Lawful Development Certificate for a Proposed Use or Development

Development: Lawful development certificate for a proposed loft conversion & internal alterations.
Location: 38 Carlton Avenue Aldwick PO21 3LP

Drawing Title:
EXISTING PLANS, ELEVATIONS

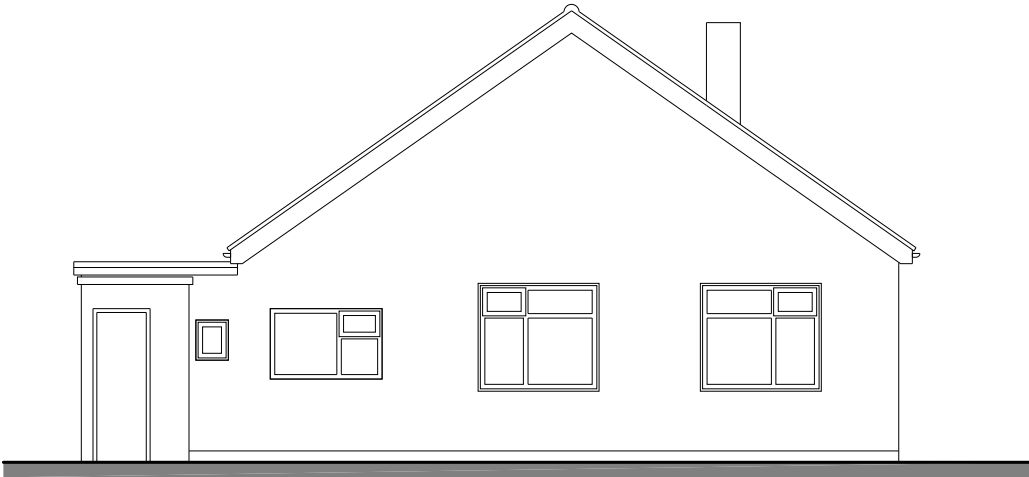
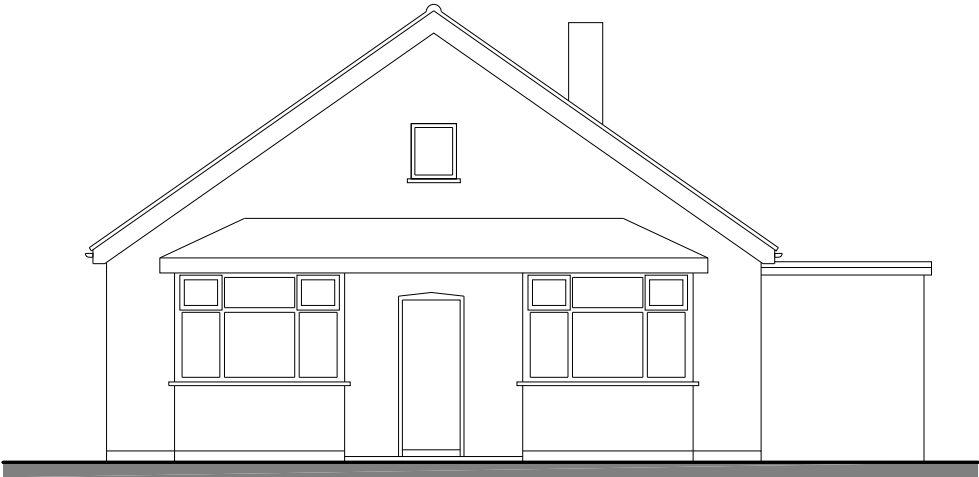
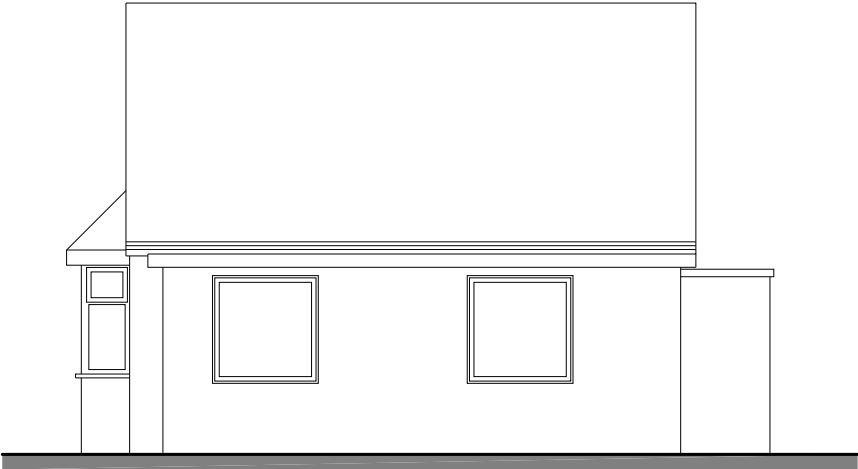
The existing and proposed elevations have been mislabelled. Please amend accordingly.
